City of Albuquerque Stormwater Construction Site Inspection Report

ESC File No.	K15E034	Project Name:	Highlands Tracts 4, 5, and 6
NPDES Id. No.	NMRT006CH	Location:	1313 Central Ave NE
11/14/2024	Property Owner	Contractor	
Operator	Cedar Investments, LLC CO Argus Dev.		
Contact name & title	Josh Rogers/Matt Lammers		
e-mail	jrogers@titan-development.com		
Contact Phone #	505-998-0163 505-515-2901		
COA Inspector	Chancellor English	Start/End Time:	2pm
Construction Phase:	graded, inactive		
Type of Inspection:	Regular	Storm Event	Post Storm Event >0.25" 311/Complaint Follow Up
Weather at time of inspection?	Clear	Temperature:	~ 60
Estimated date of last storm 0.25" or greater	11/7/2024

TEMPORARY EROSION AND SEDIMENT CONTROL PLAN

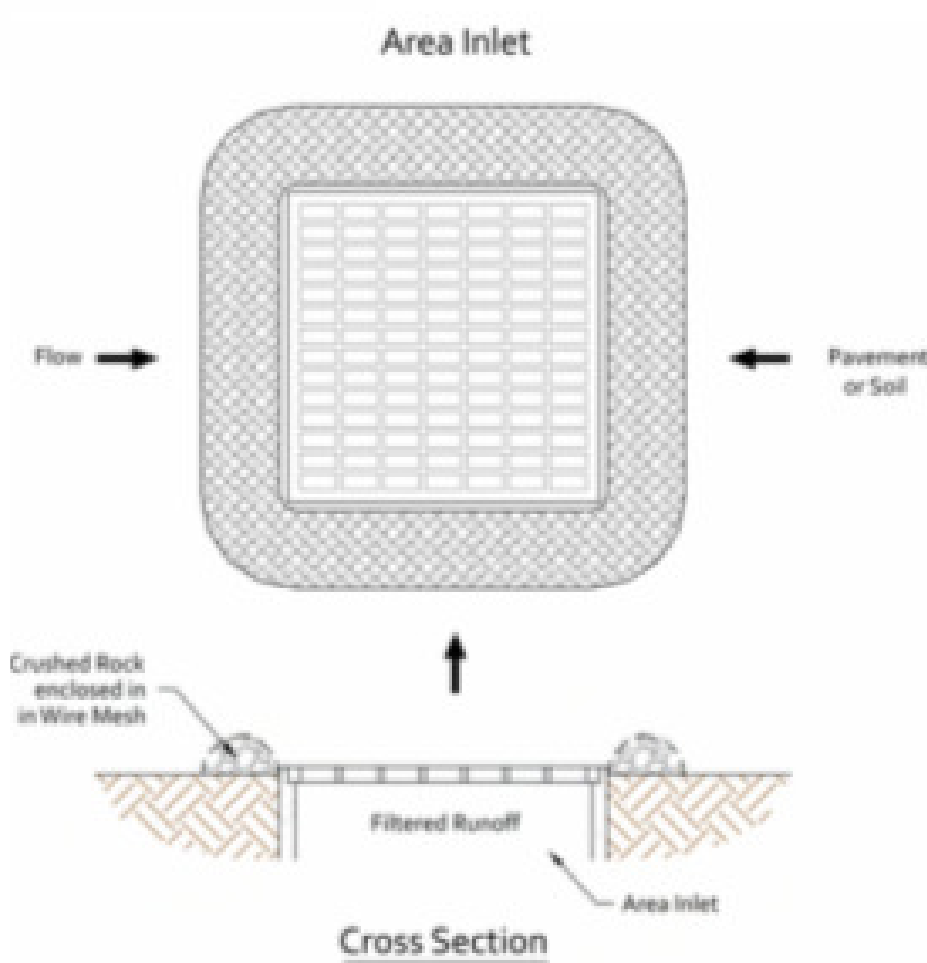
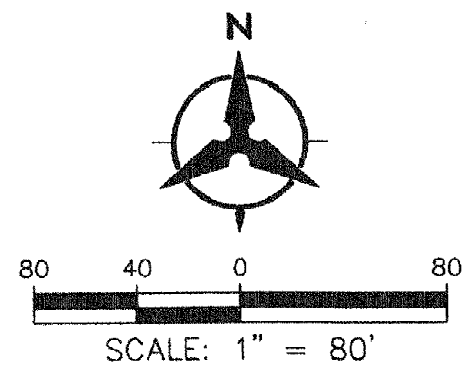
Item Number	Deficiency/ Corrective Action
1	There is still sediment deposits along Cedar St. and neighboring property in violation of CGP Part 2.2.4. Required mitigation: Where sediment has been tracked-out from your site onto paved roads, sidewalks, or other paved areas outside of your site, removed the deposited sediment by the end of the same business day in which the track-out occurs or by the end of the next business day in which the track-out occurs on a non-business day. Remove the track-out by sweeping, shoveling, or vacuuming these surfaces, or by using other similarly effective means of sediment removal. You are prohibited from hosing or sweeping tracked-out sediment into any constructed or natural site drainage feature, storm drain inlet, or receiving water per CGP Part 2.2.4.
2	Stabilization - The bare soil has had no construction activity for a long period of time without any stabilization measure installed in violation of CGP Part 2.2.14. Required mitigation: Initiate the installation of stabilization measures immediately in any areas of exposed soil where construction activities have permanently ceased or will be temporarily inactive for 14 or more calendar days, and complete the installation of stabilization measures as soon as practicable, but no later than 14 calendar days per CGP Part 2.2.14.
